Rezoning Petition Review

Rezoning Petition #: 20-39

Location of Property: Approximately 0.44 acres located north of Firefighter Pl, east of 7th St and west of Weddington Ave.

**SKETCH PLAN**

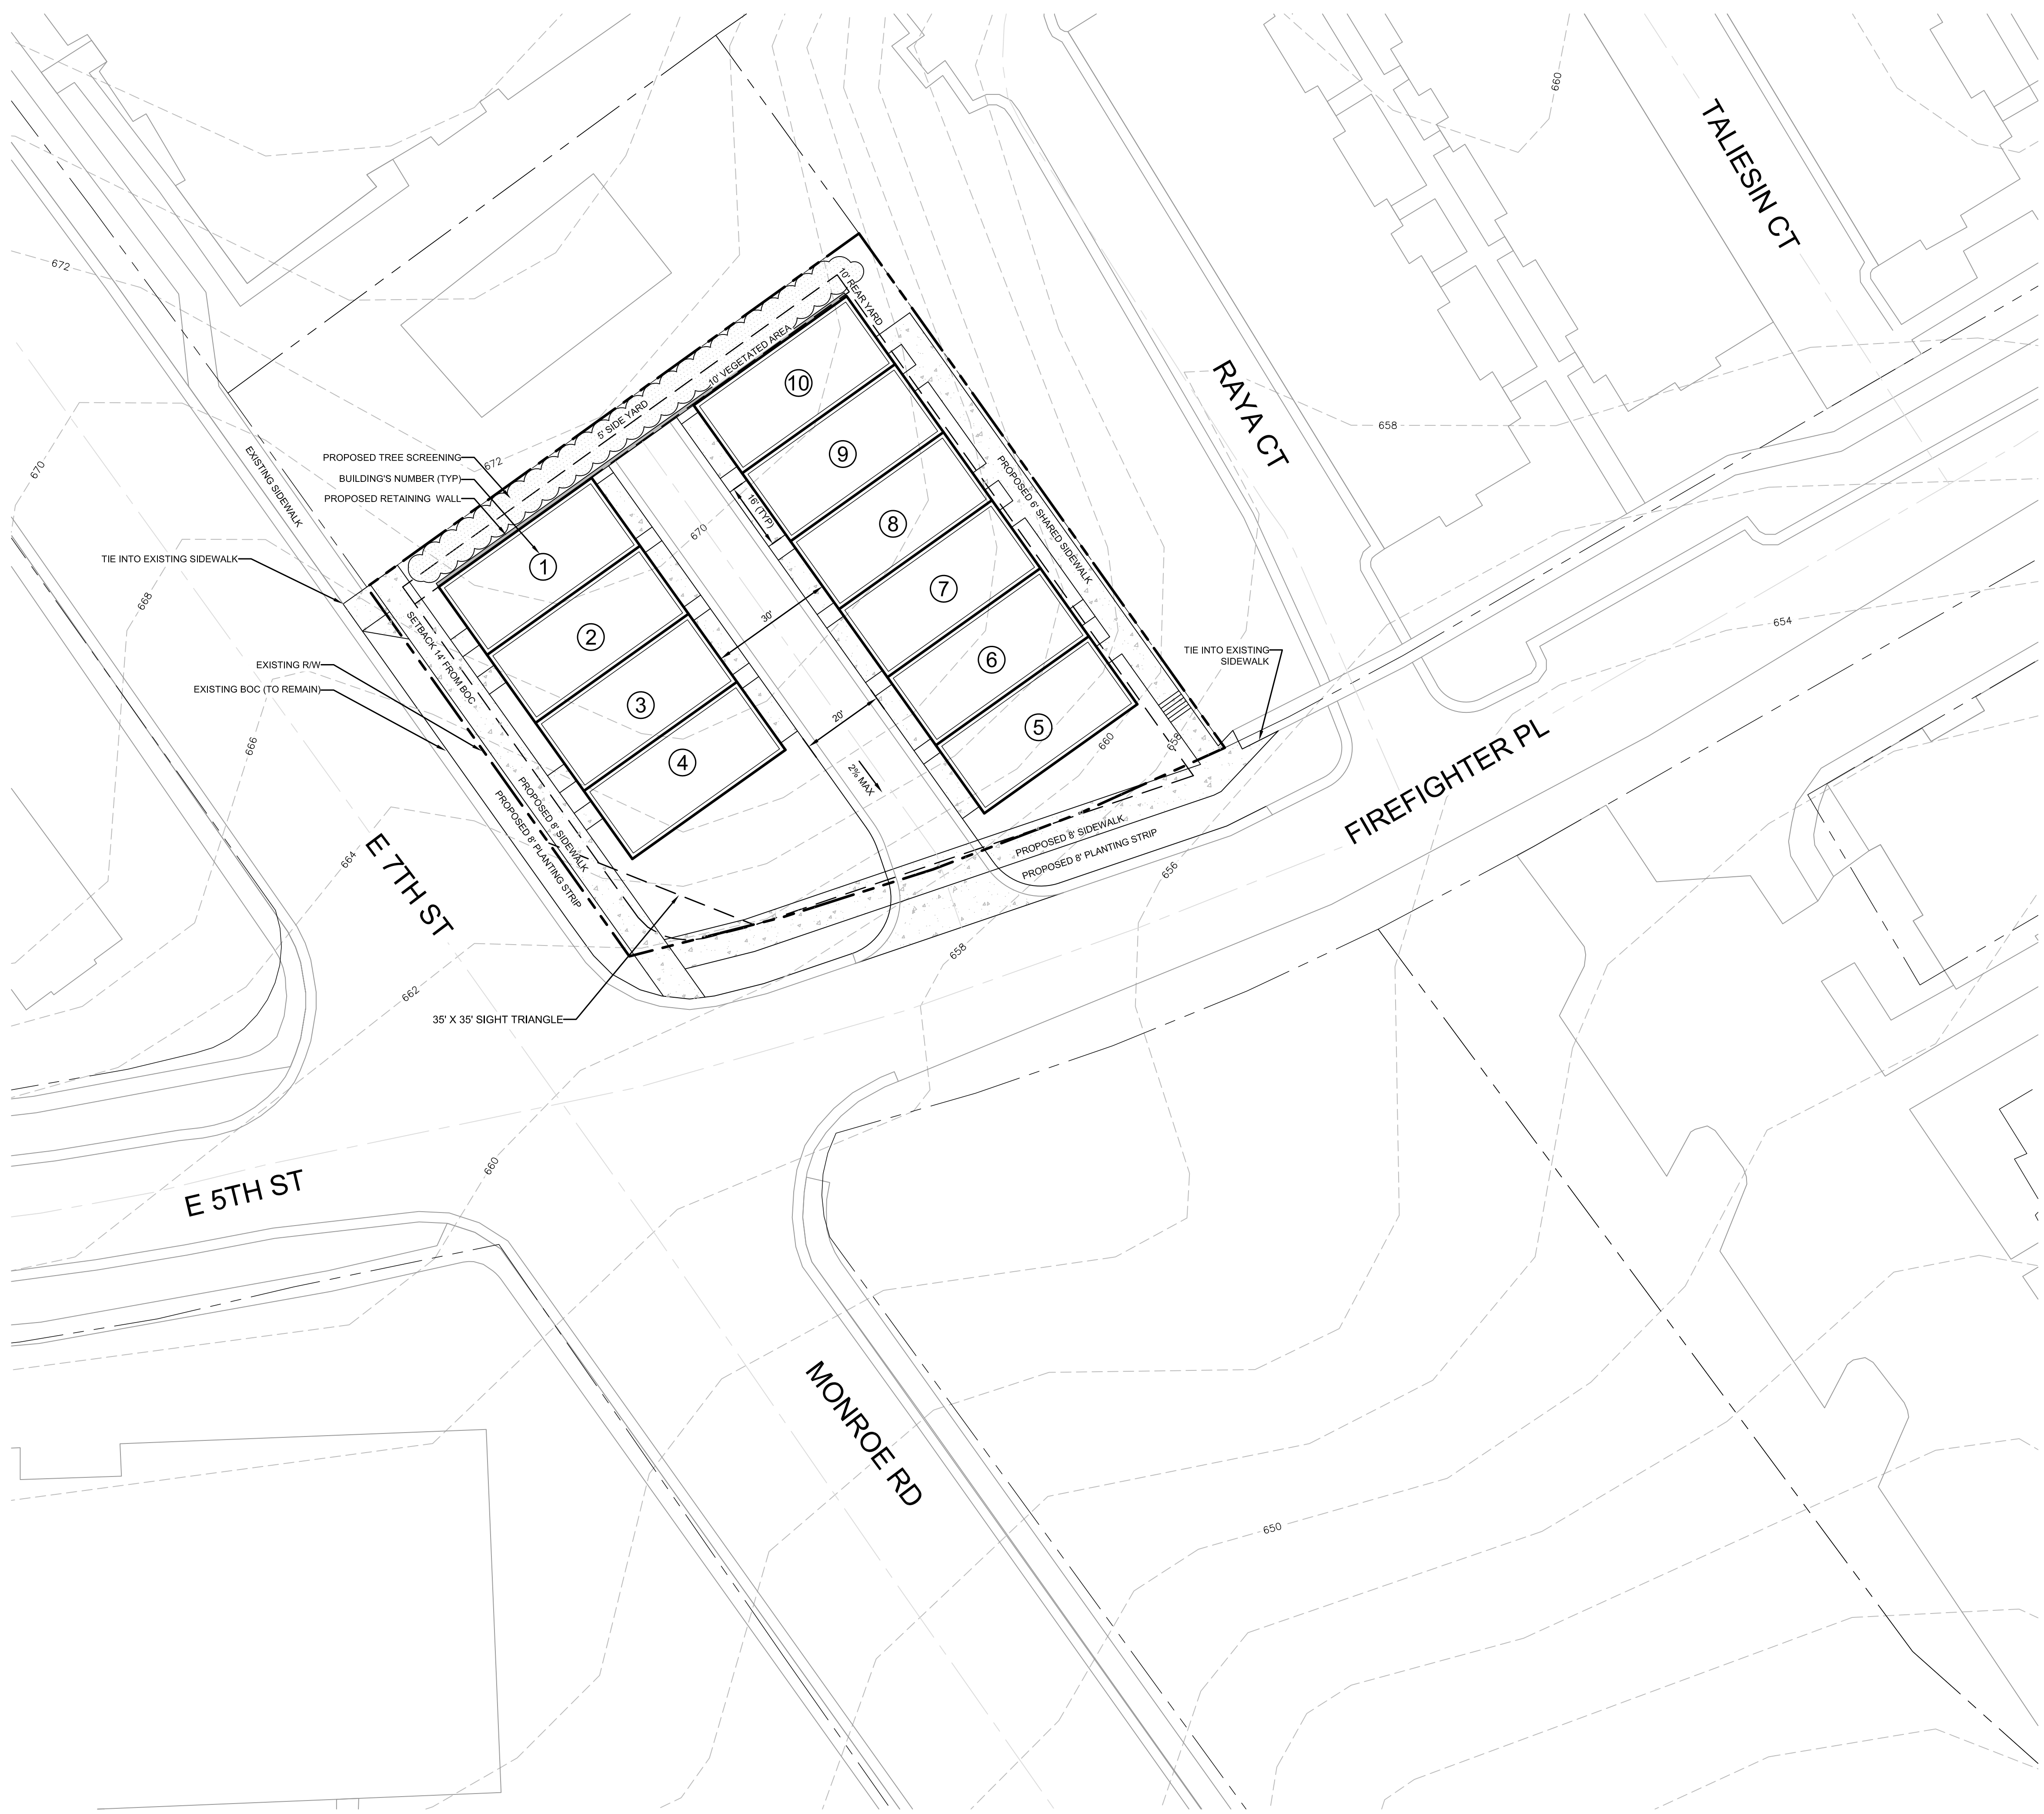
This property drains to Briar Creek, which is an impaired/degraded stream, and may contribute to downstream flooding. This project has the opportunity to mitigate future impacts to this stream, therefore, Storm Water recommends placing the following notes on the plan:

For defined watersheds greater than 24% built-upon area (BUA), construct water quality stormwater control measures (SCMs) designed for the runoff generated from the first 1-inch of rainfall for all new and redeveloped BUA associated with the project. SCMs must be designed and constructed in accordance with the Charlotte-Mecklenburg BMP Design Manual.

For defined watersheds greater than 24% built-upon area, control the entire volume for the 1-year, 24-hour storm for all new and redeveloped BUA associated with the project. Runoff volume drawdown time shall be in accordance with the Charlotte-Mecklenburg BMP Design Manual.

For commercial projects with greater than 24% BUA, control the peak to not exceed the predevelopment runoff rates for the 10-yr, 6-hr storm and perform a downstream flood analysis to determine whether additional peak control is needed and if so, for what level of storm frequency, or if a downstream analysis is not performed, control the peak for the 10-yr and 25-yr, 6-hour storms.

For residential projects with greater than 24% BUA, control the peak to not exceed the predevelopment runoff rates for the 10-year and 25-year, 6-hour storms or perform a downstream analysis to determine whether peak control is needed, and if so, for what level of storm frequency.
